North Kesteven District Council response to Deadline 3 submissions

Document/reference	NKDC comments
Outline Decommissioning and Restoration Plan	NKDC raises no specific comments on the ODRP at this stage however refers to the provisions of draft Requirement R18 below.
Draft DCO Revision 5	<p>NKDC makes the following comments in relation to Revision 5 of the draft DCO, with some of the below points overlapping with the EXA’s second questions:</p> <p>Requirements</p> <p><u>R3 (Phasing)</u> – the revision does not address the comments submitted at deadline 3 ‘Action Points’. We understand the need for some flexibility to be able to depart from a masterplan in response to matters such as unforeseen supplier issues or local constraints however we still consider it important that broad geographical principles of phasing should be submitted to and should be approved by the RPAs.</p> <p><u>R6 (Detailed design)</u> – the draft now includes reference to outline design concepts plan and that the detailed design will be informed by findings of archaeological surveys. This addresses concerns raised by the Council’s archaeologist in terms of the flexibility provided by the Rochdale envelope.</p

Steel Mesh 'Deer Fencing'

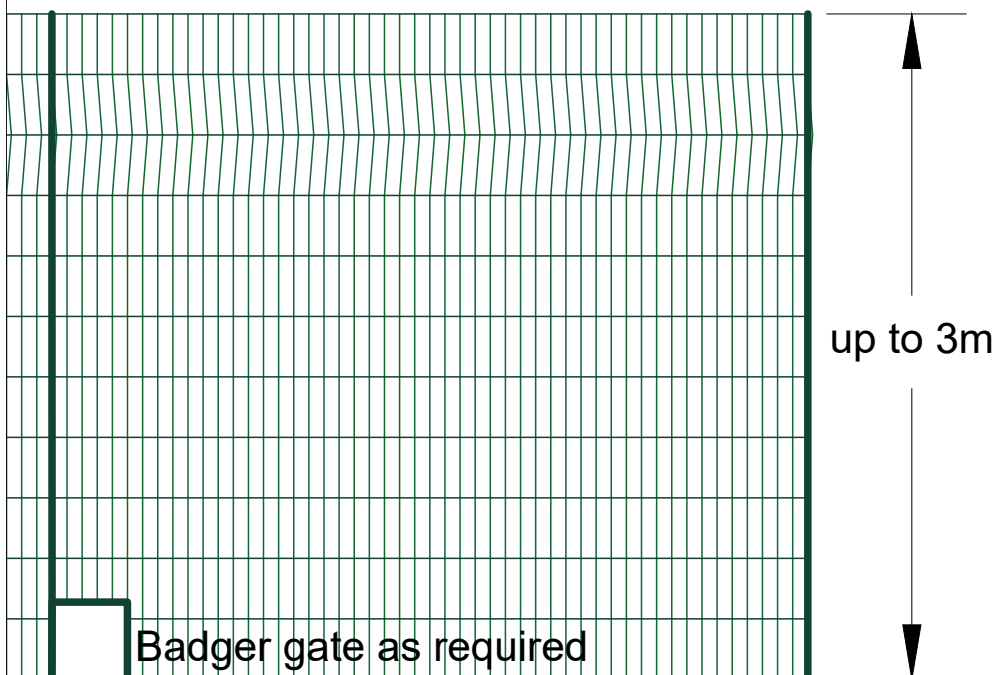
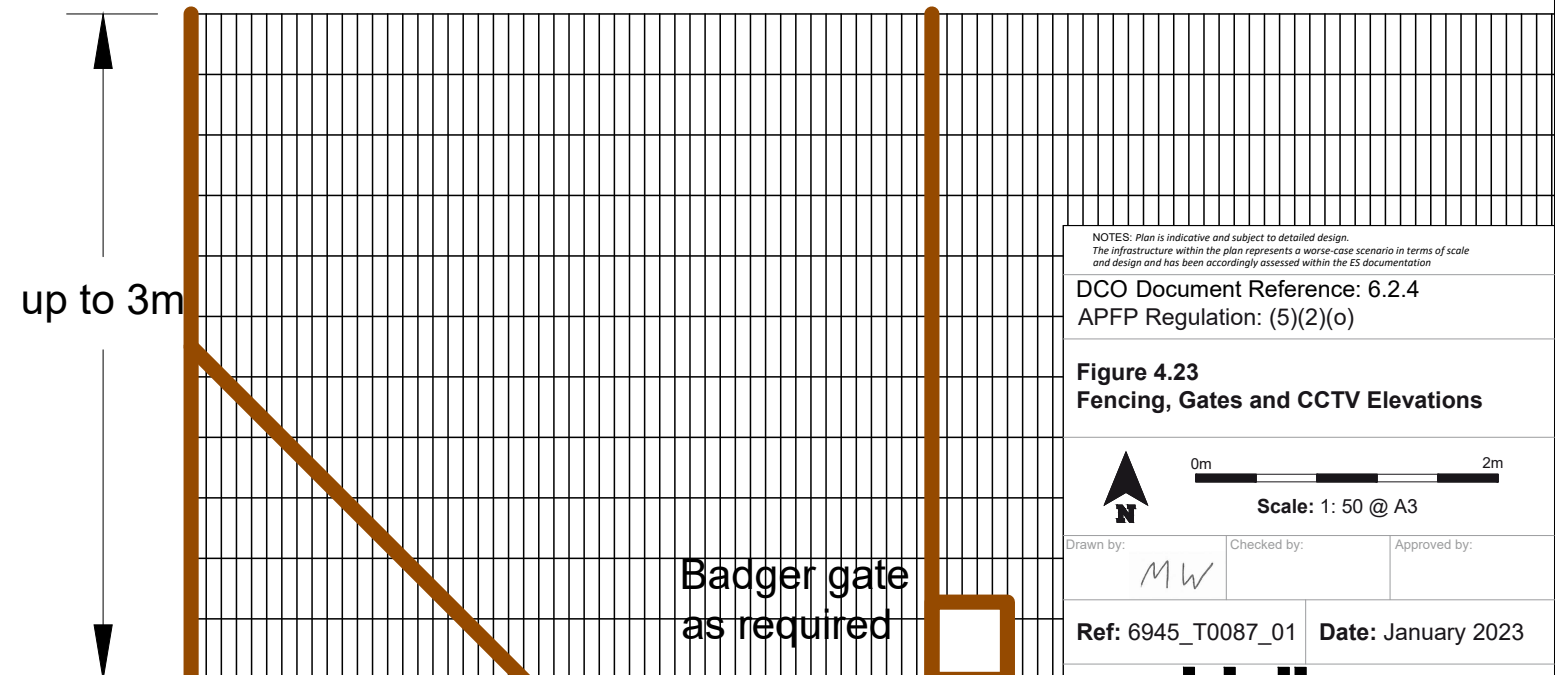
R10 (Fencing) – as set out at deadline 3, any details must align with recommendations contained in the LEMP regarding deer fencing/exclusion.
